**CITY OF MERCER ISLAND
DESIGN COMMISSION
FINDINGS OF FACT AND CONCLUSIONS
OF LAW**

**Agenda Item: X
May 16, 2024**

Project:	Monaco Villa Condominiums Repair and Remediation (DSR24-002)
Description:	A Design Commission Design Review application to repair and remediate the Monaco Villa Condominiums. The scope includes the removal of all damaged and failing existing siding at the north, east, and south elevations. The architectural massing would also be improved as part of the repair.
Applicant:	James Ramil and Tess Cleary (Evolution Architecture) for Joe Peloso (Monaco Villa Condominiums Property Manager)
Site Address:	2929 76th Avenue SE, Mercer Island WA 98040; Identified by King County Assessor tax parcel number 5569600000
Zoning District:	Multiple Family (MF-2)
Exhibits:	<ol style="list-style-type: none">1. Design Review Plan Set, dated January 24, 2024 prepared by Evolution Architecture2. Project Narrative3. Study Session Notes

ORIGINAL DESIGN
PRESENTATION

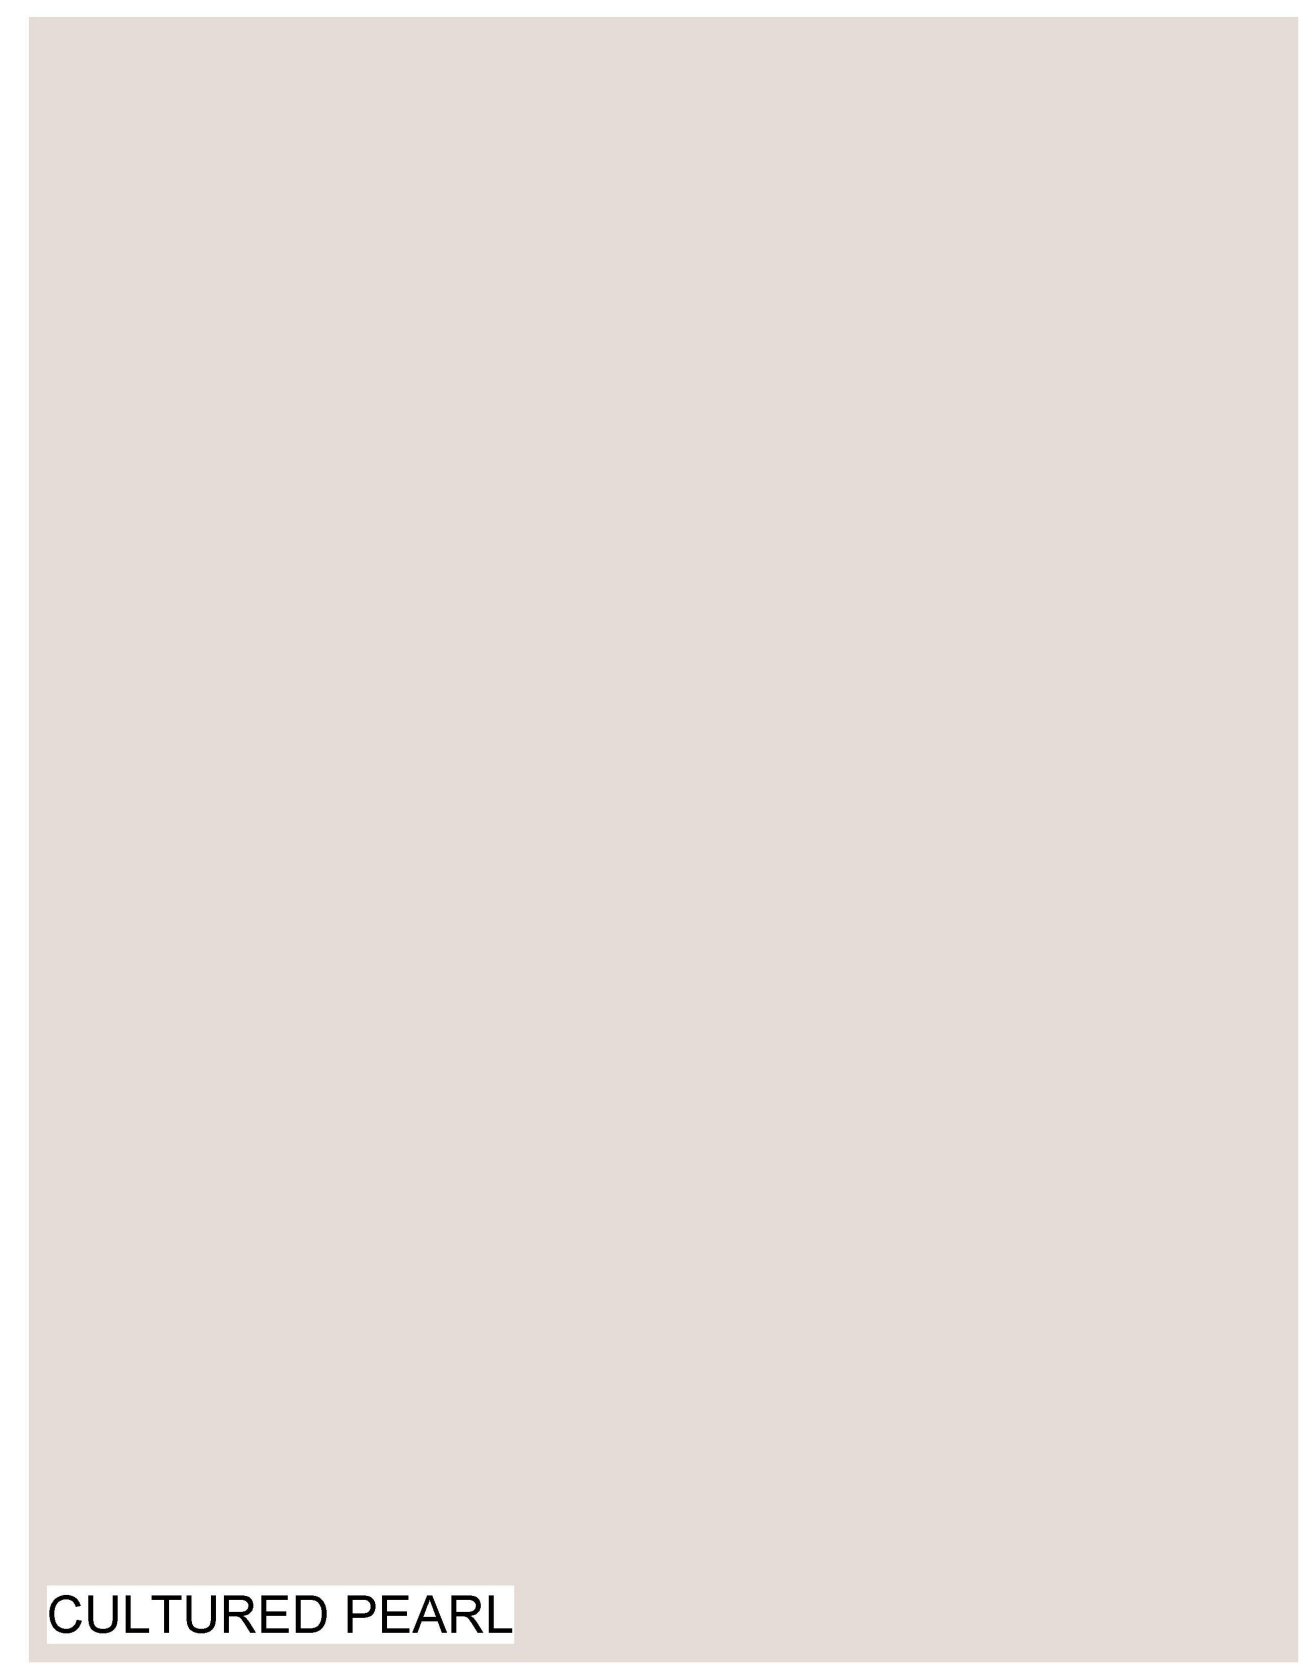
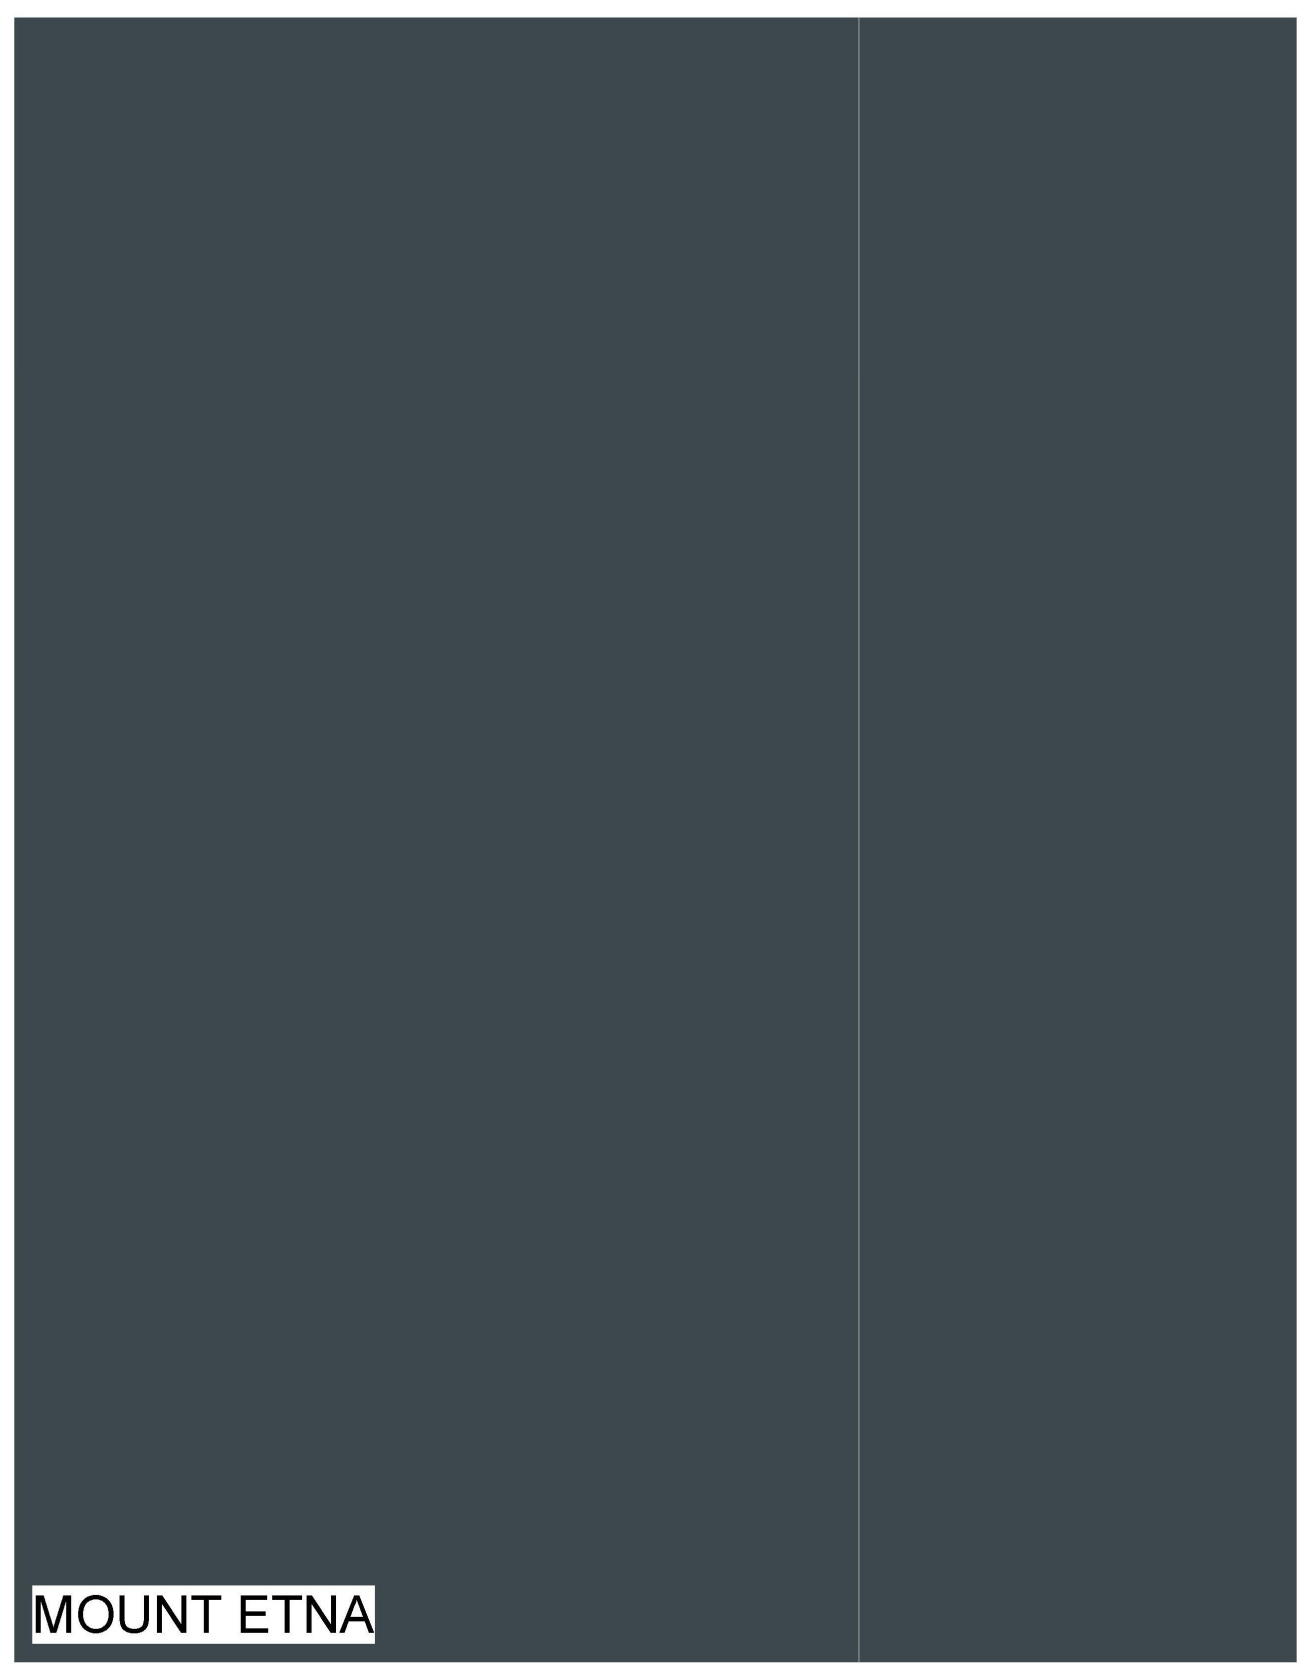
- Materials –
 - Trespa seems to be a flat material and presents in one face (timestamp 1:23:40)
 - The amount of Trespa on the front elevation makes the material look not as high quality (timestamp 1:28:10)

- Facade feels “paper thin”. The existing arches feel more monolithic and monumental, and when they are broken up with the hardy reveals, they start to feel thinner in materiality. Suggestion to turn the corner with the material (timestamp 1:30:41)

- Super graphics –
 - How is the classical architecture of the building interpreted with the super graphic? (timestamp 1:25:00)
 - Existing foliage at the ends of the building gives more license to have a cleaner and simpler design due to the wall acting as a backdrop to the trees (timestamp 1:26:53)

**ENLARGED AERIAL
VIEW**

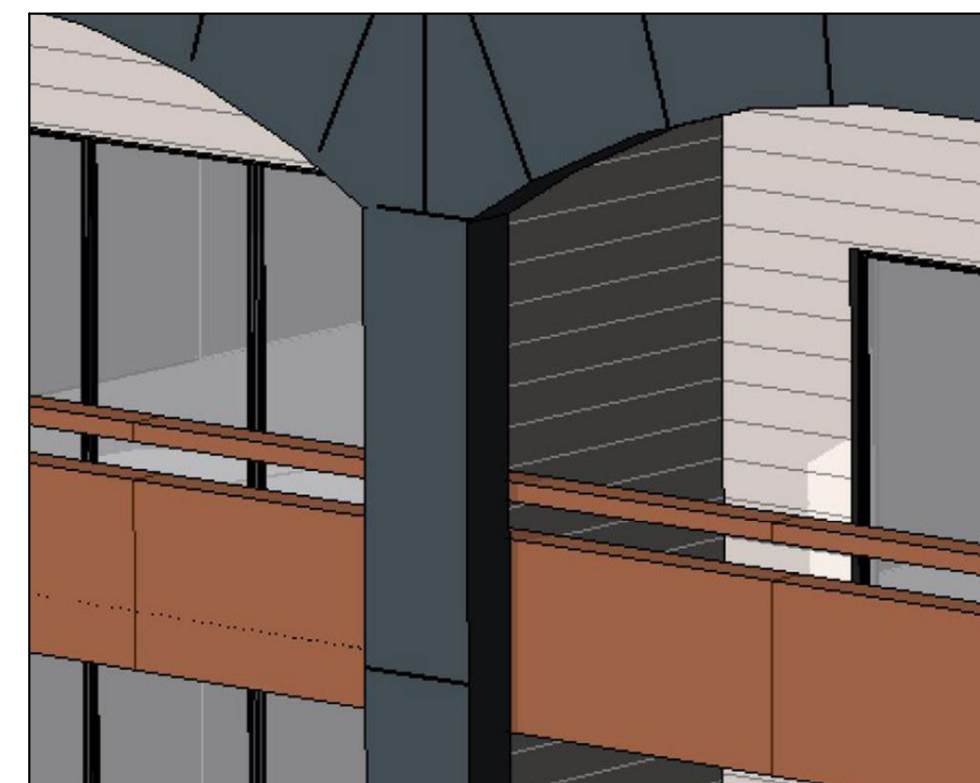
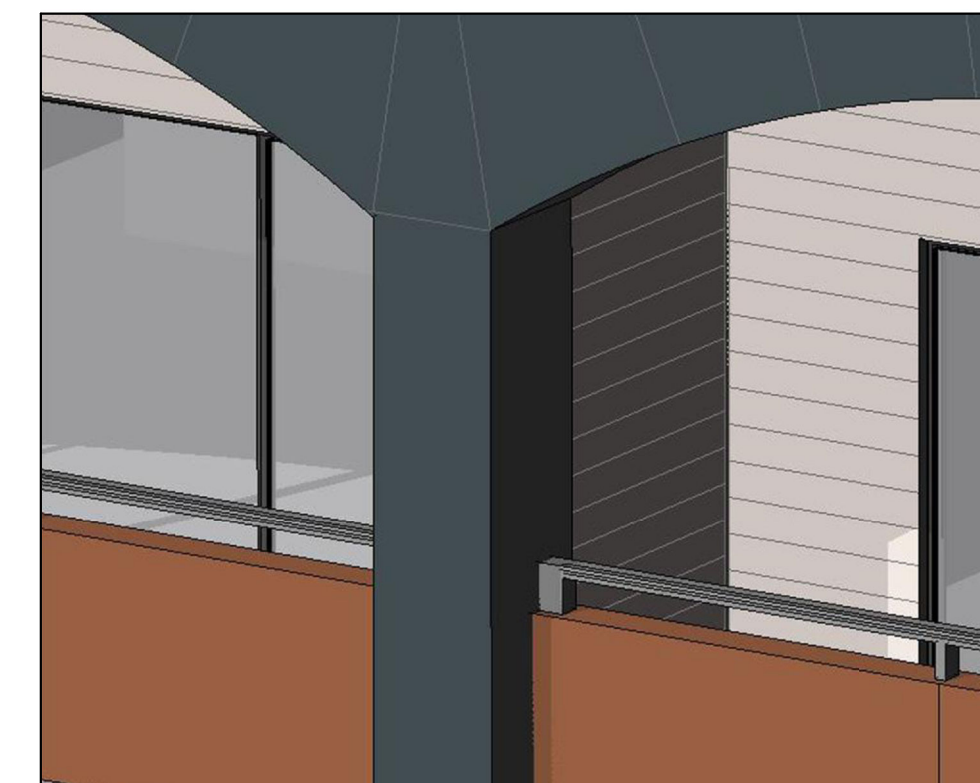
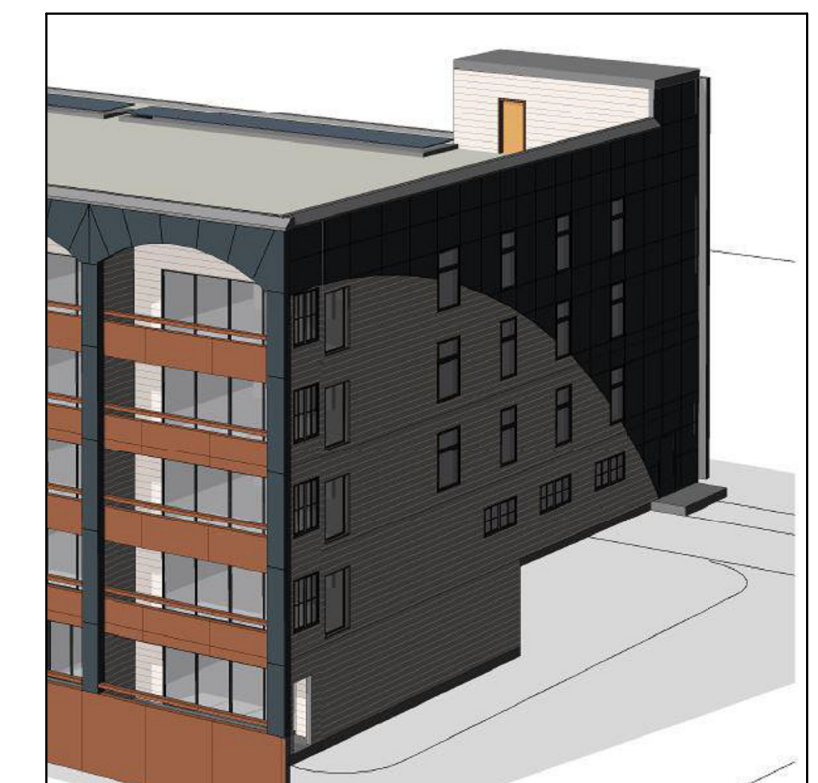
Staff Finding: The proposed scope of work involves removing the non-structural columns at the balconies, which improves the overall bulk and mass of the exterior of the building by making the existing arches more proportionate to the size of the building. Based on Design Commission feedback during the study session, the proposal includes doubling the depth of the remaining columns to give them a more substantial presence and clarity.

Staff Finding: The proposed scope of work includes modification to the existing balconies by removing the non-structural columns in the middle of the balconies. The proposal also includes doubling the depth of the remaining columns to give them more substantial presence and clarity.
